CITY OF ALBUQUERQUE

**RE: East Century Gateway Plaza
Grading and Drainage Plan
Engineers Stamp Date 6/11/14 (K20-D061)**

Based upon the information provided in your submittal received 6/11/2014, the above referenced Grading and Drainage Plan cannot be approved for Grading Permit or Building permit until the following comments are addressed.

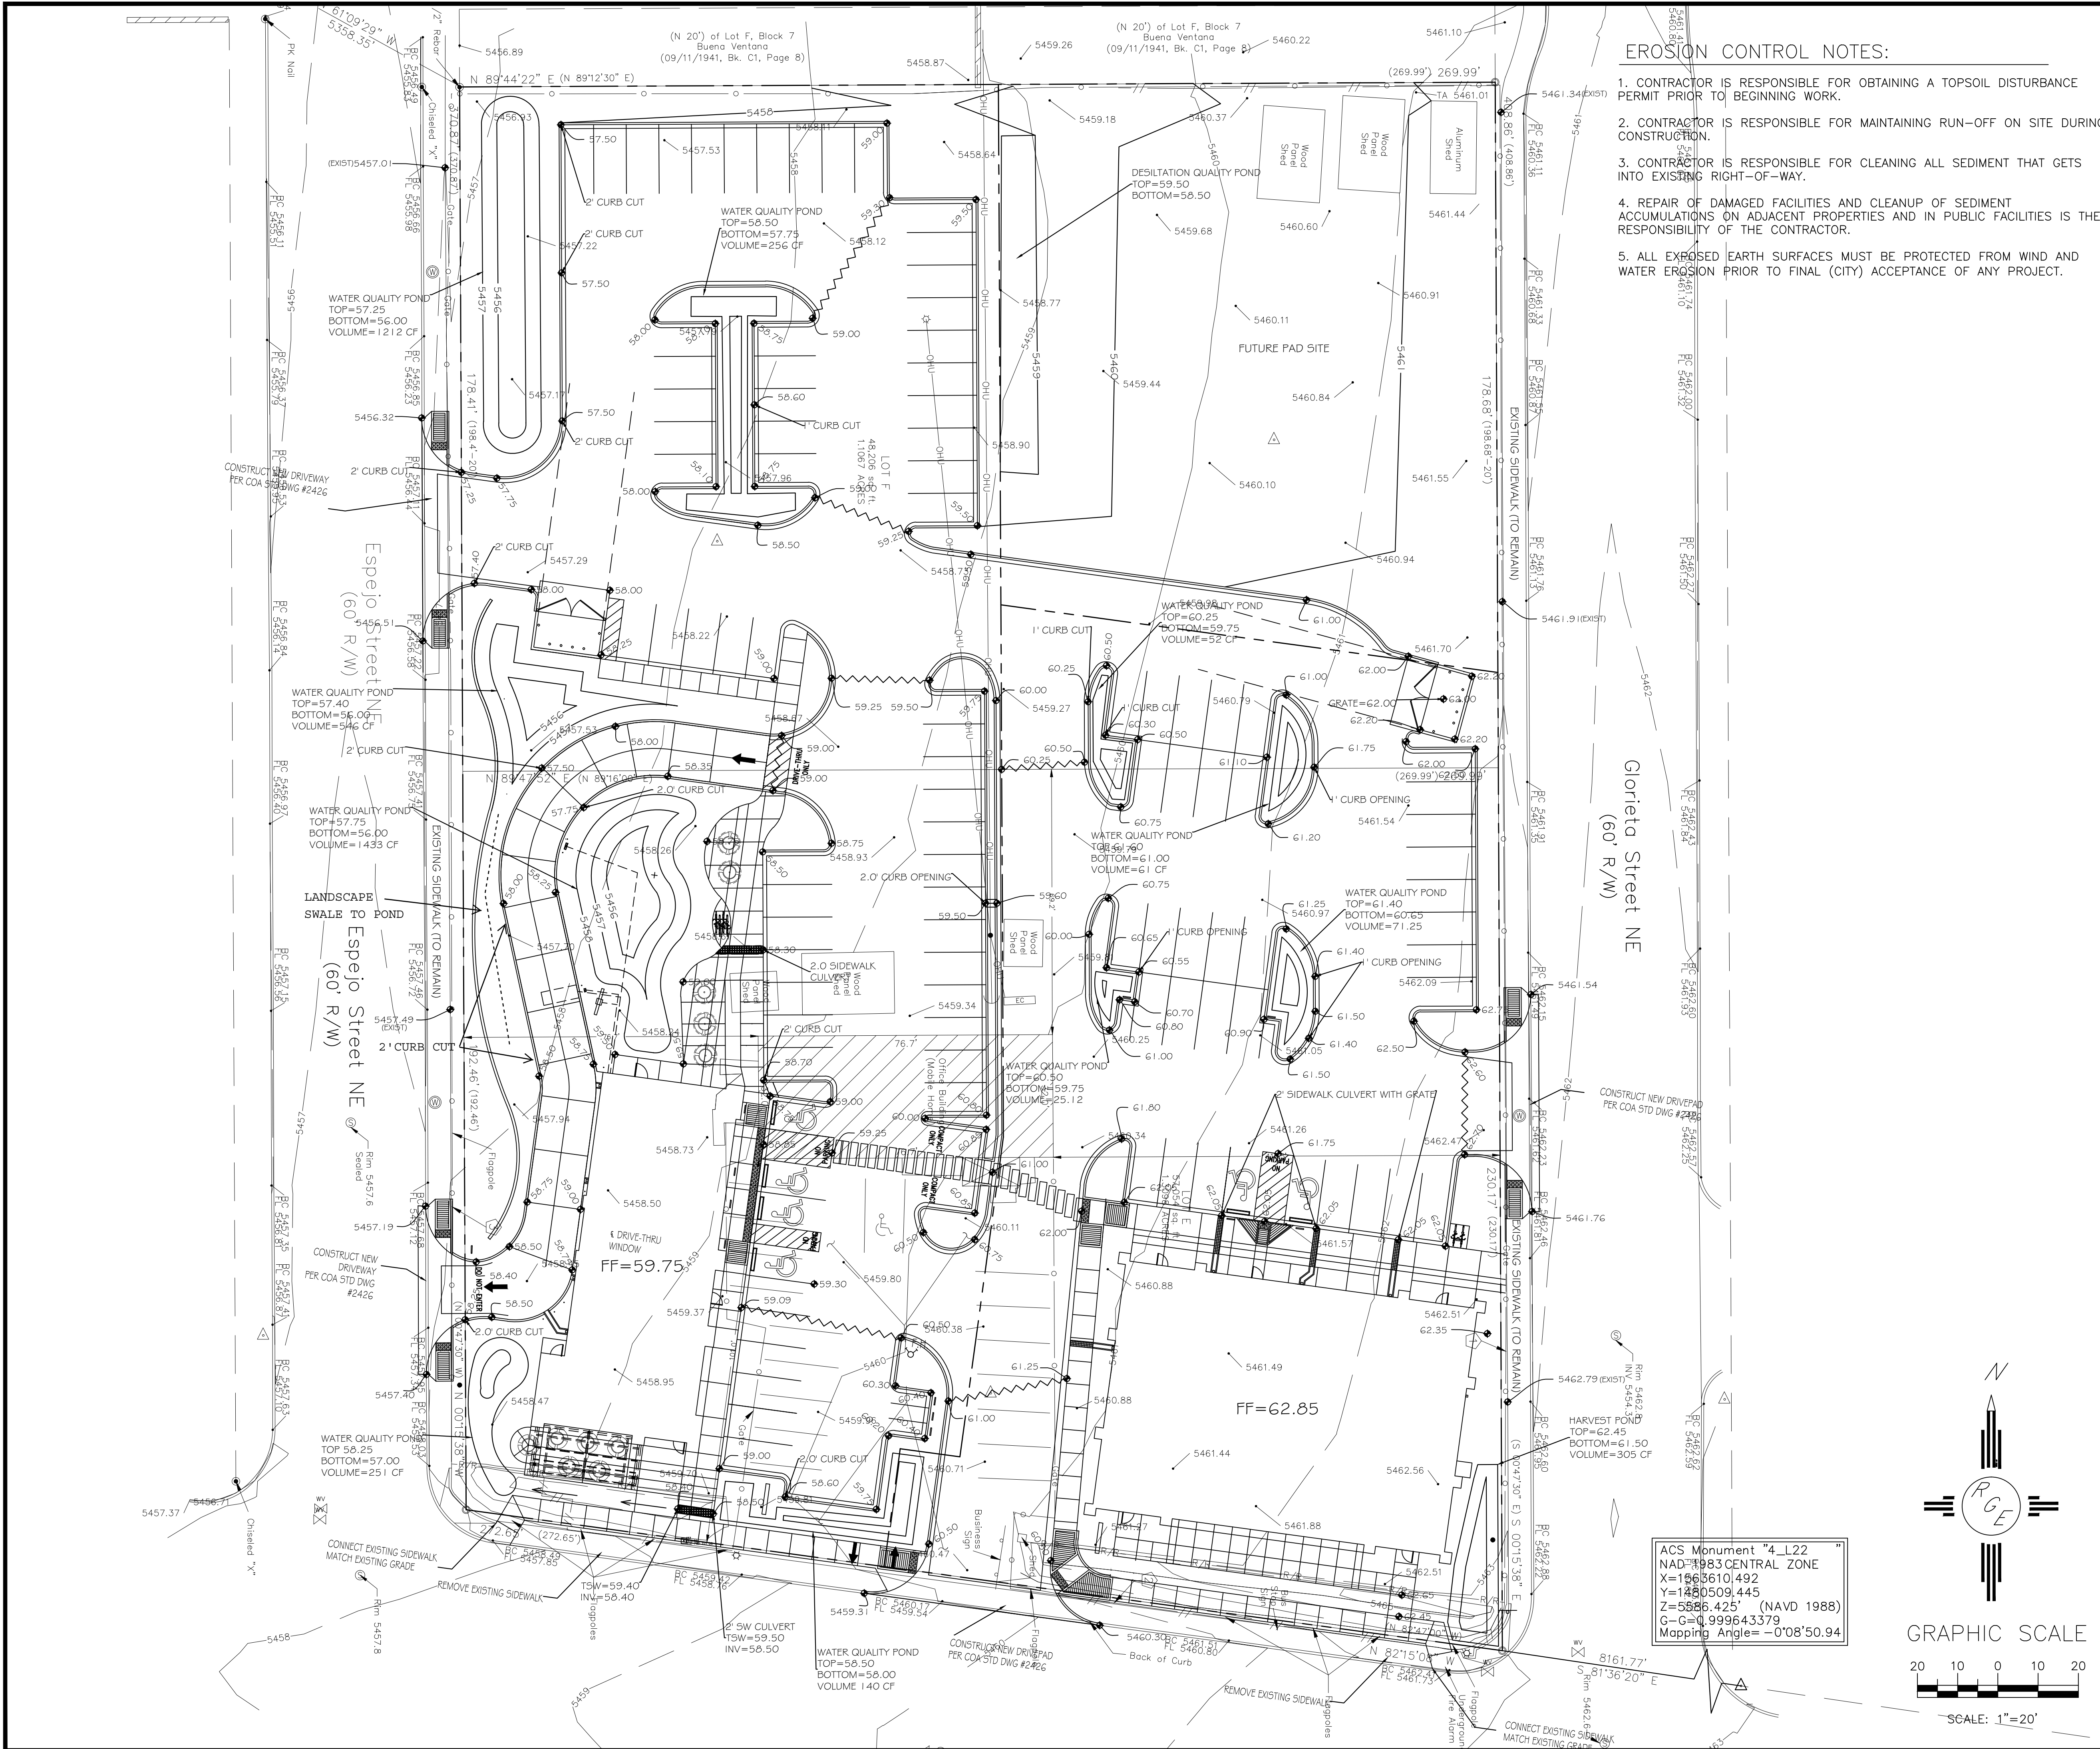
- A drain with a grease trap needs to be placed in the trash enclosure.
- Add two foot curb cuts spaced every 20 feet in the drive thru lane.
